ENG-SF22025-R1-GEC.pdf Markup Summary

PCD File # SF-22-25

GRADING & EROSION CONTROL PLAN  
 EROSION CONTROL

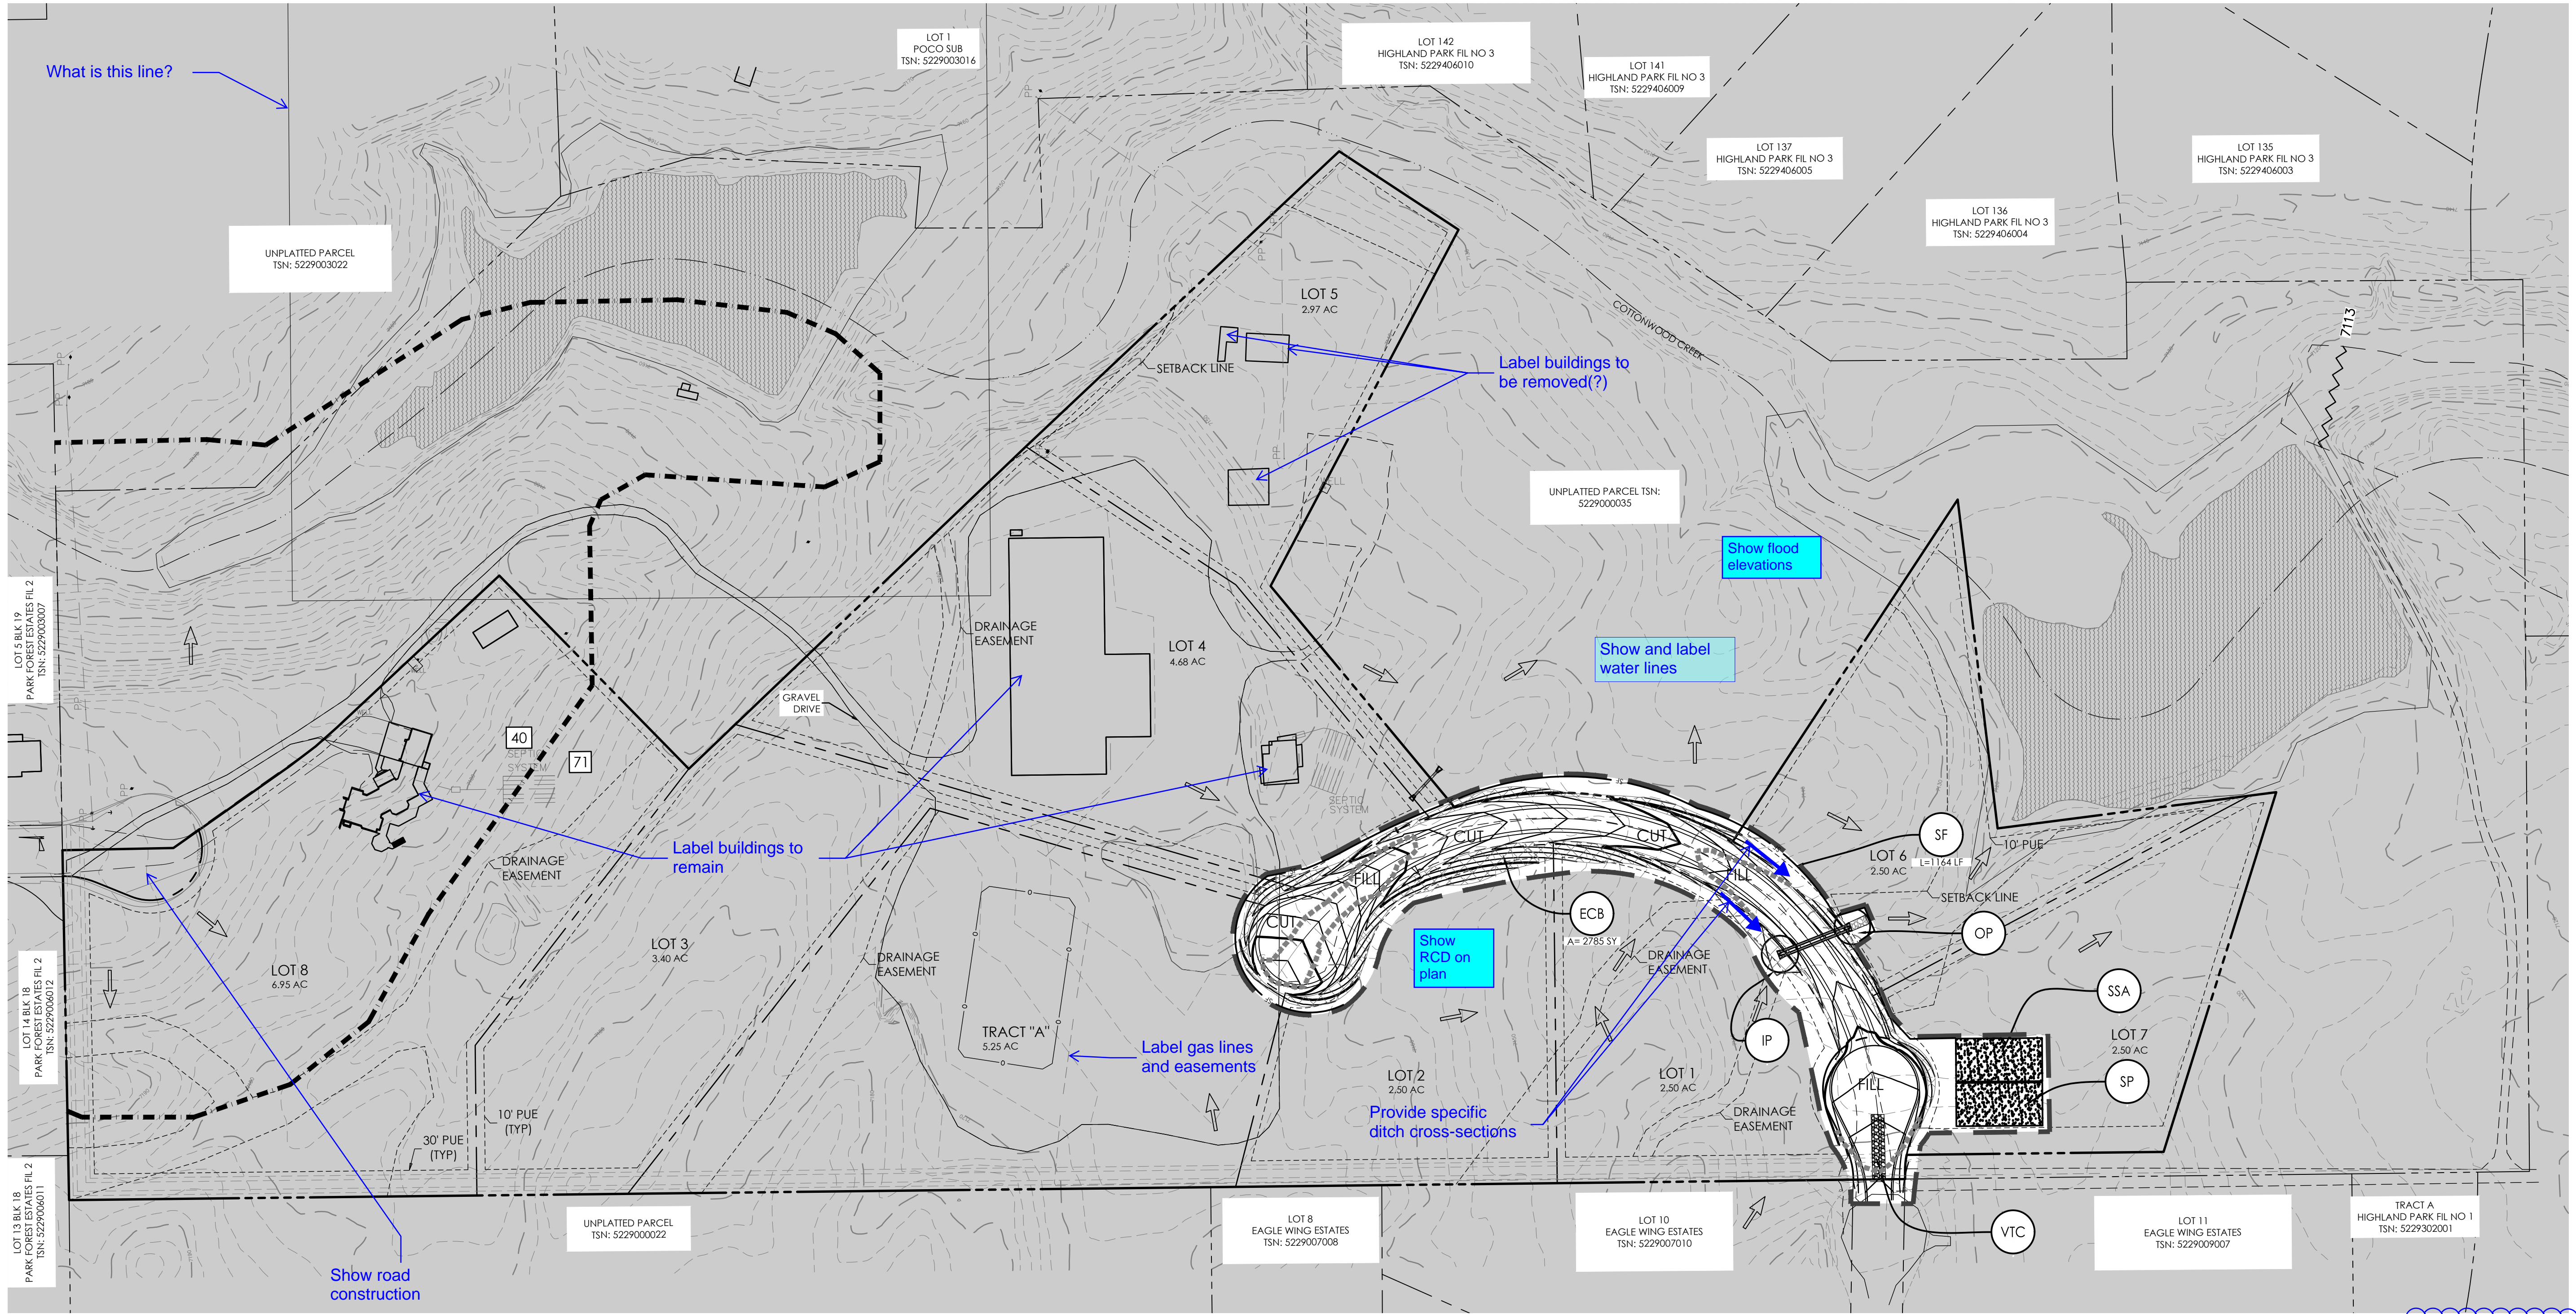
Lots have no build lines on several lots due to studied floodplain per plan. Please correct statement

Show flood elevations

Label buildings to be removed(?)

Show road construction

Label buildings to remain

What is this line?

Provide specific ditch cross-sections

Label gas lines and easements

Show and label water lines

Show RCD on plan
